Permit #952, 48 State St.

I am reviewing your permit application for zoning compliance and I had a few questions.

BASEMENT FLOOR PLAN

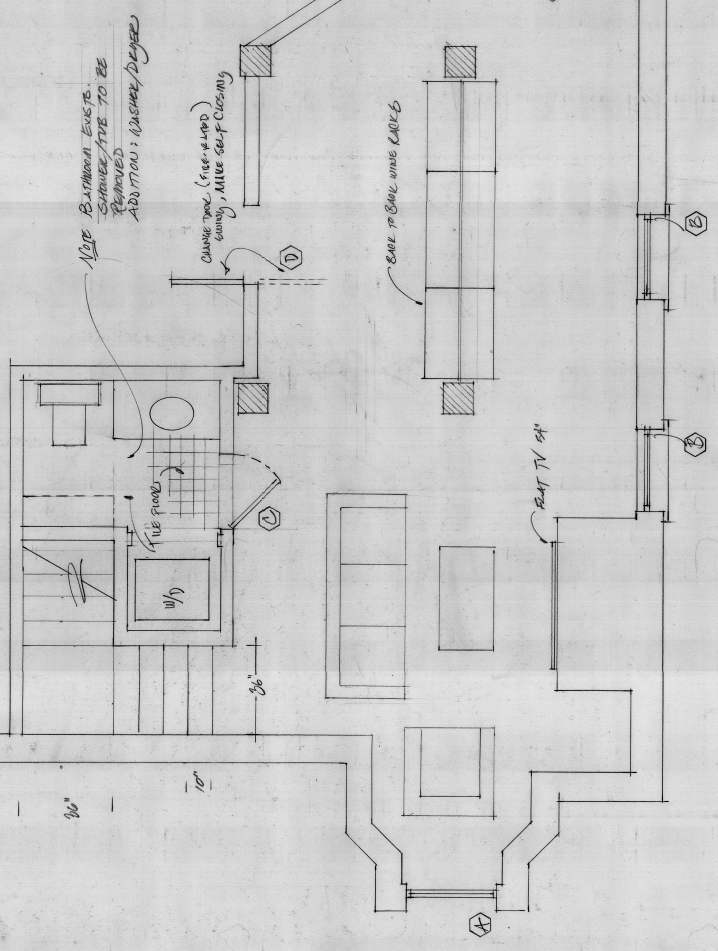
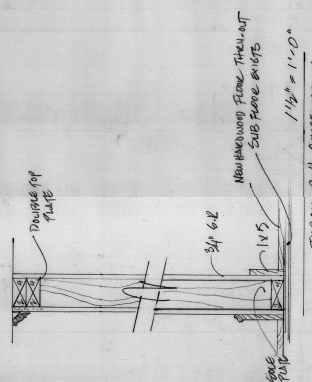
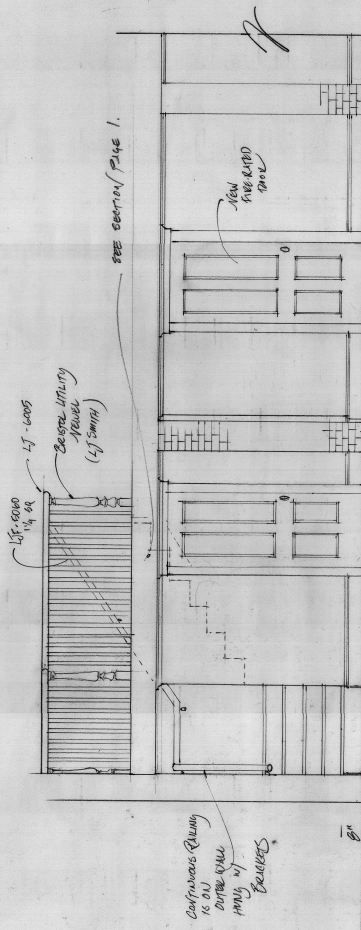
Finally, your application says that you will be finishing the space for "storage" but the designer's drawing shows living space as well - couches and a TV. Can you confirm which is correct?

3. Please ignore the TV and seats that are in the plan. It is meant for storage (which is what it is today). I have no desire to watch TV in the basement. I think she (the designer) just thought it would be nice to have this, but I'm not interested in it.
